## Cairn Homes Development - Castletreasure

### Road Safety Audit: Stage 1

April 2019

Drawing Title
PHASING PLAN

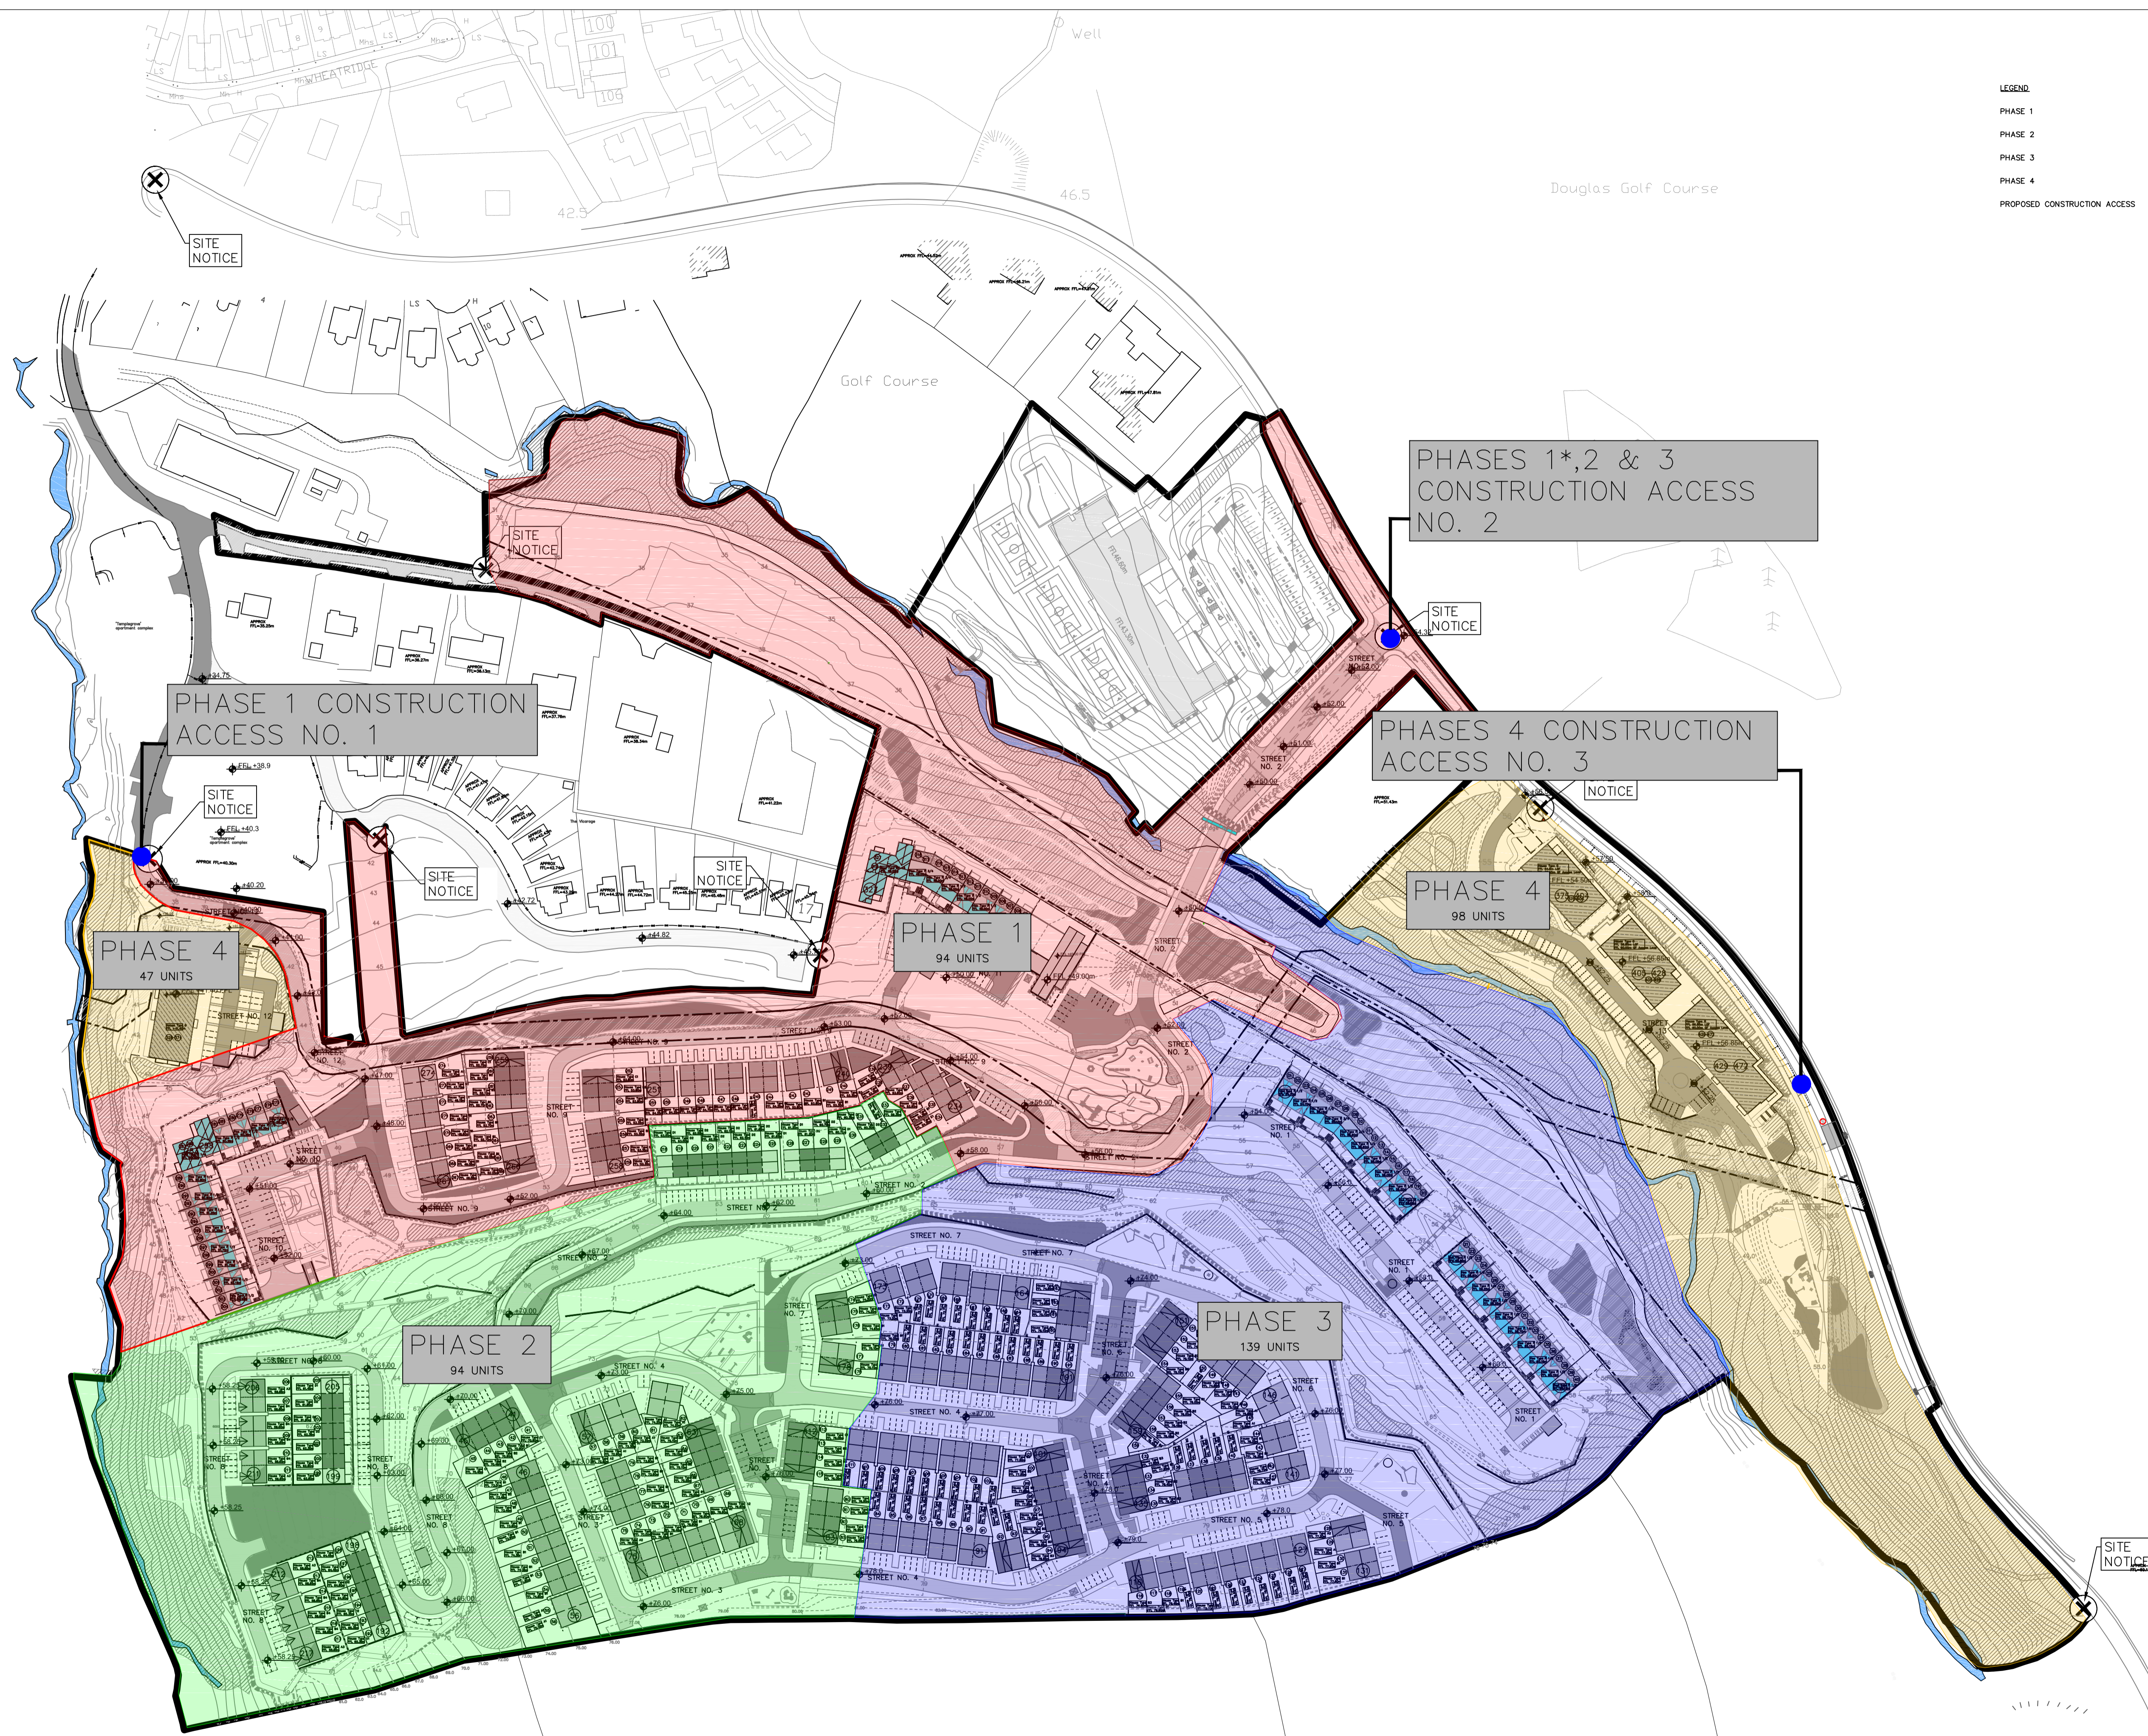
The cul-de-sac at the south-eastern corner of the development is missing a turning head. This will result in an increase in complex reversing manoeuvres, and an associated increased risk to vulnerable road users.

Whilst it is noted that turning heads may not be required for short cul-de-sacs, a turning head should be provided for the longer more complex cul-de-sacs such as the one in Figure 15. Turning heads will minimise the requirement for vehicles, particularly larger goods or refuse vehicles, having to reverse long distances.

3.8	No	No	This is a short spur, cul de sac serving 4 no dwellings with a raised surface and play areas.  A turning area is not required in our opinion.	Yes
